Planning Inspectorate (the Drovers Solar
Farm)

Reference: OR-0009338/01
Customer reference: EN0110013

**Deadline 3 submissions response letter
The Drovers Solar Farm**

This letter constitutes the Environment Agency's Deadline 4 response regarding the Deadline 3 submissions. It is structured as follows:

DRAWING TITLE:
Figure 12.13: Work No. 2 Maximum Potential Foundations and Groundwater Elevations

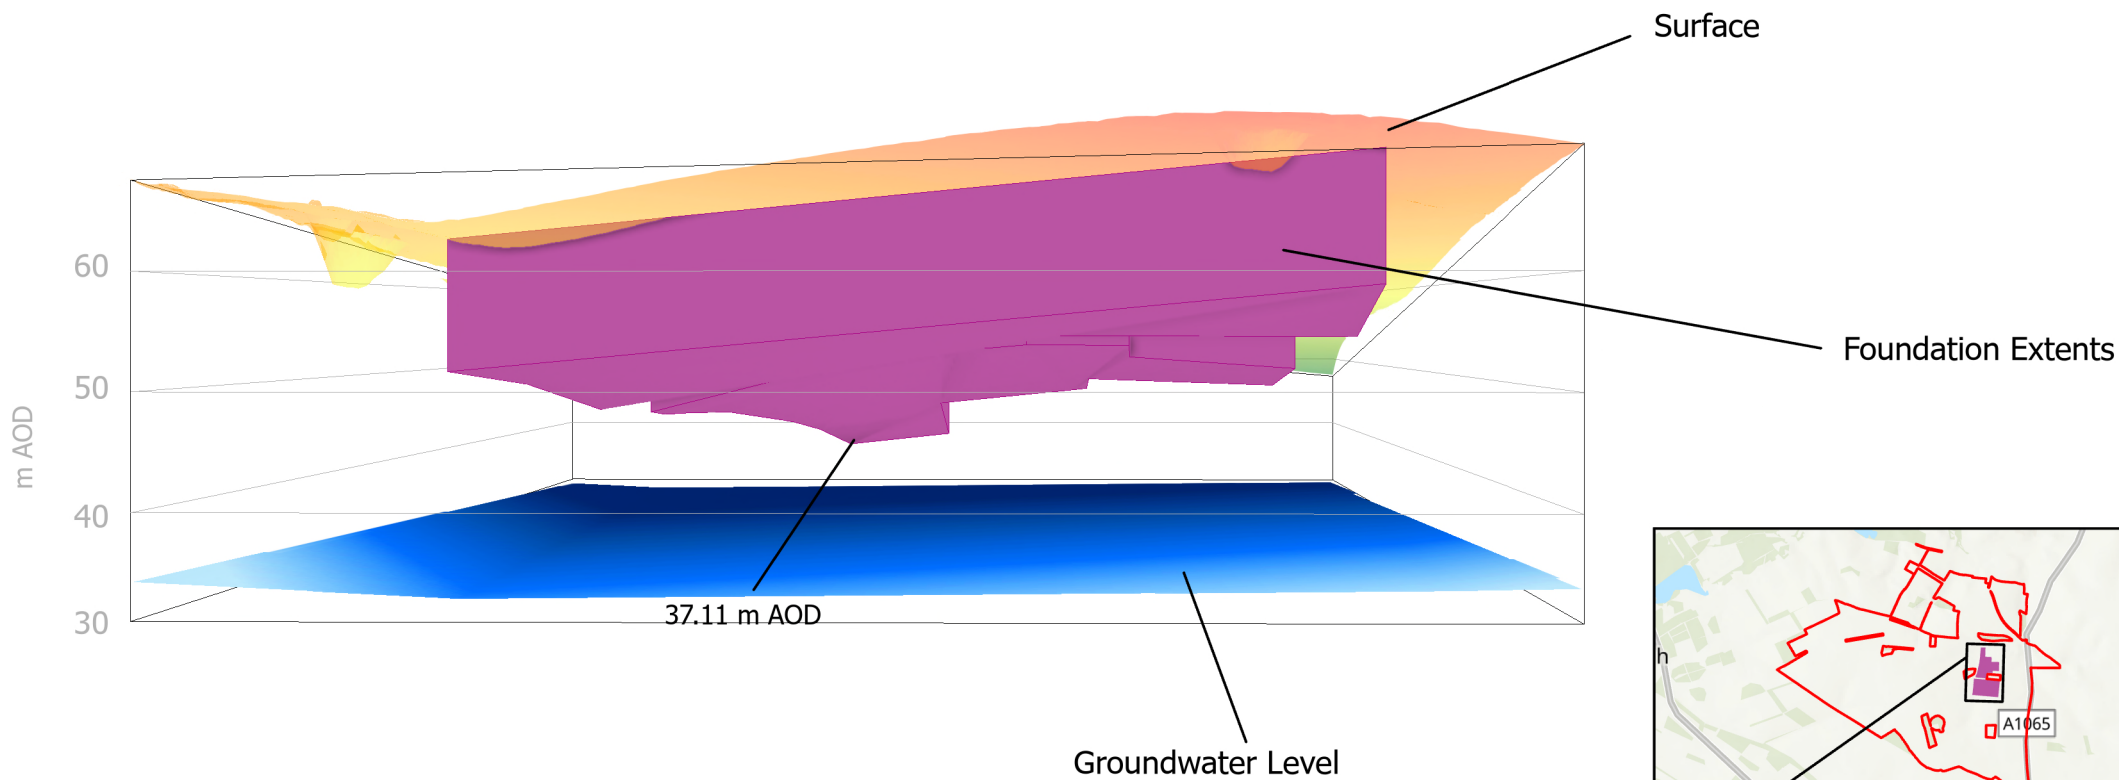
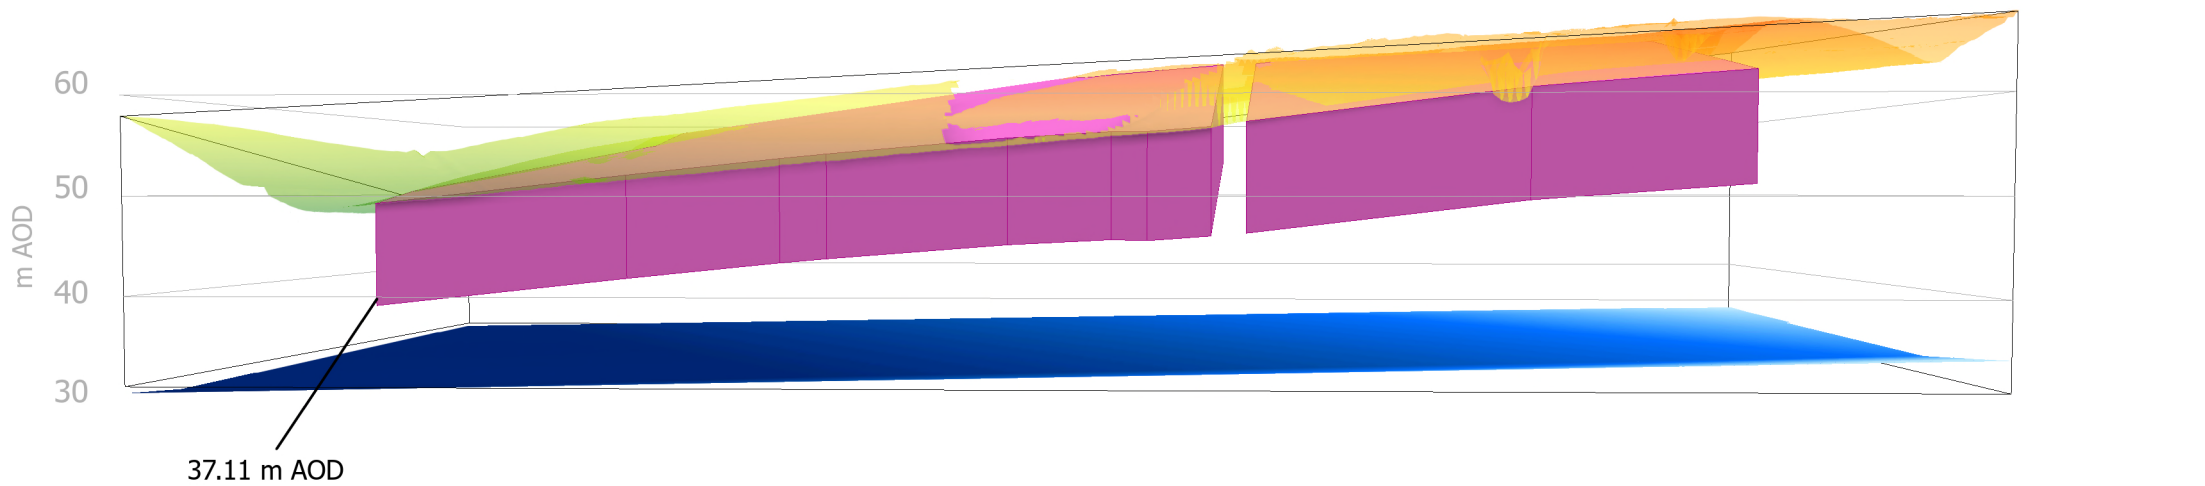
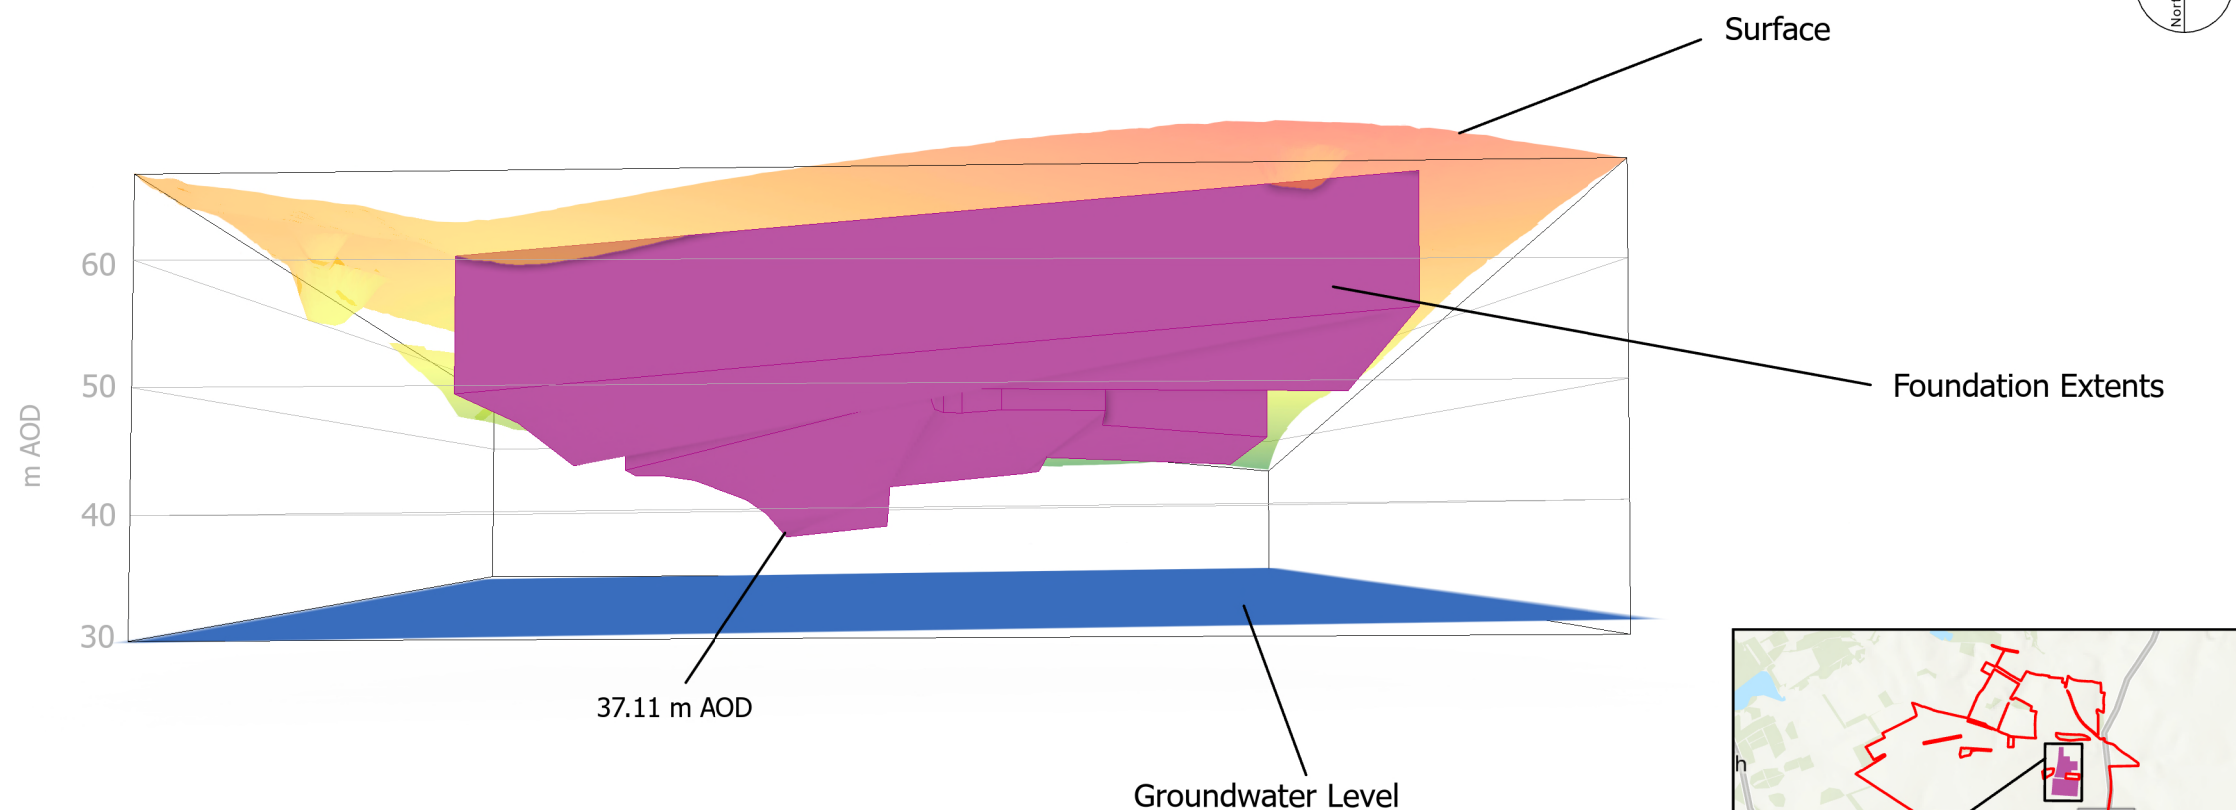
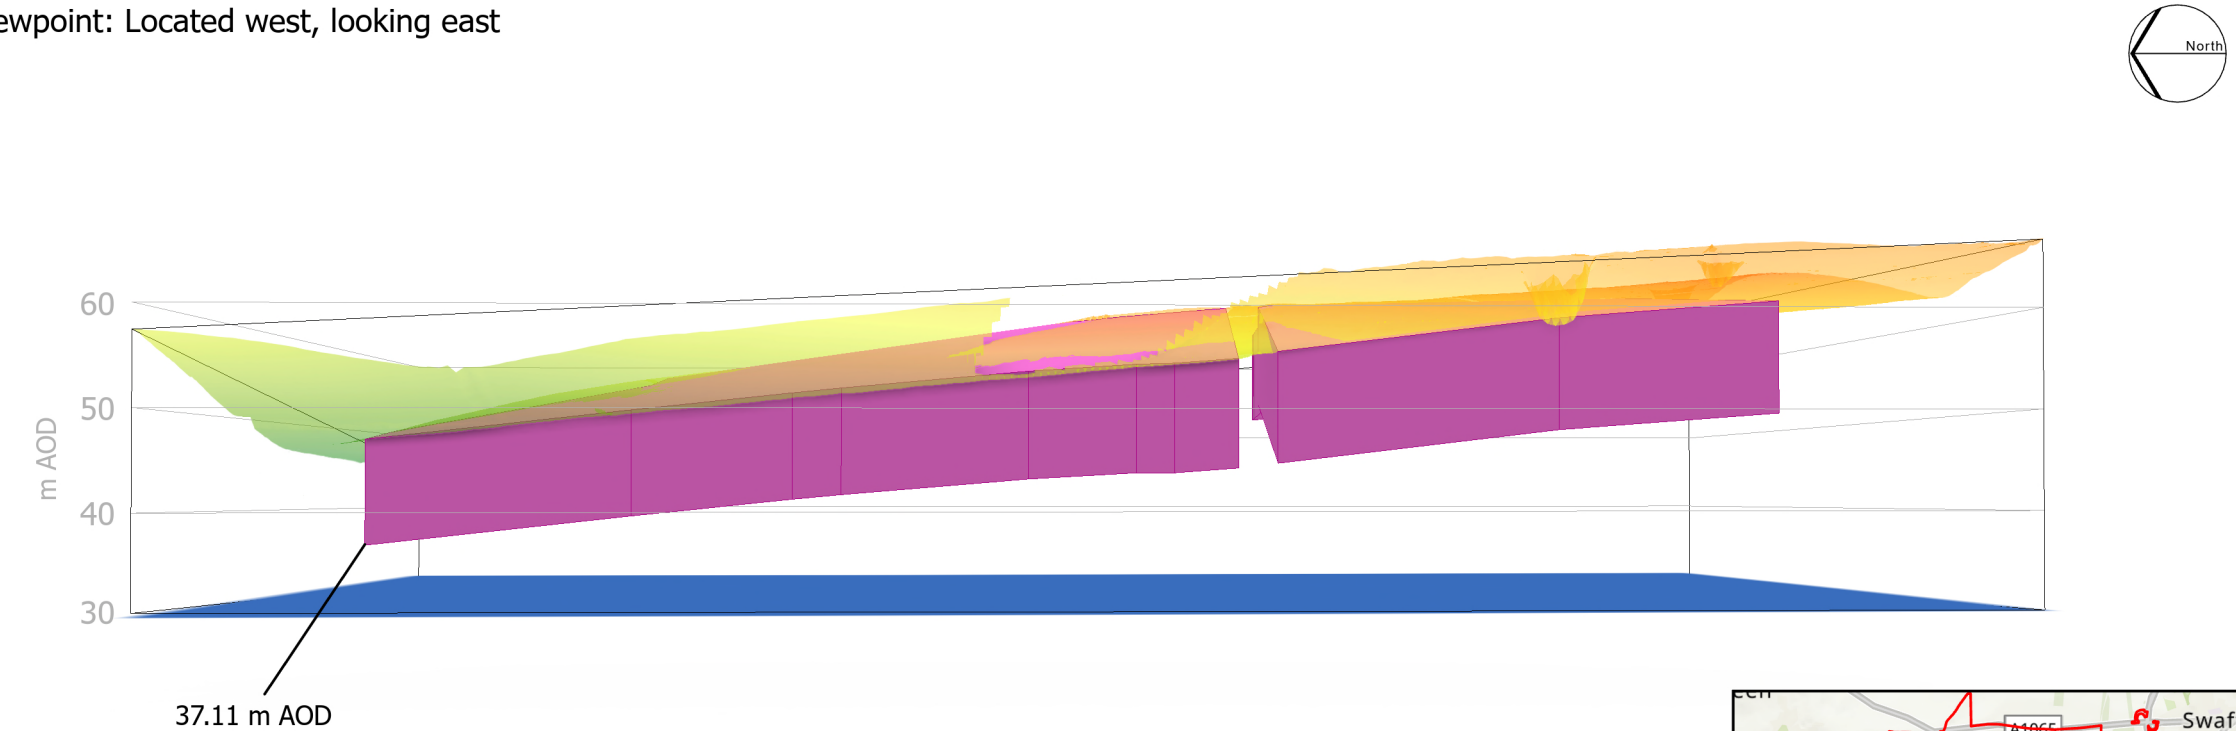
We were concerned that figures 12.13 [[APP-127](#)], 12.14 [[APP-128](#)], 12.15 [[APP-129](#)] and 12.16 [[APP-130](#)] do not clearly define the area represented by the drawings, including view orientation, or the elevation values.

- 6.3.1 ES Figure 12.13 Work No. 2 Maximum Potential Foundations and Groundwater Elevation [[REP3-043](#)]
- 6.3.1 ES Figure 12.14 Work No. 3 Maximum Potential Foundations and Groundwater Elevation [[REP3-044](#)]

We find the updated figures satisfactory for defining the 3D model view, and elevation the maximum extent of the foundations.
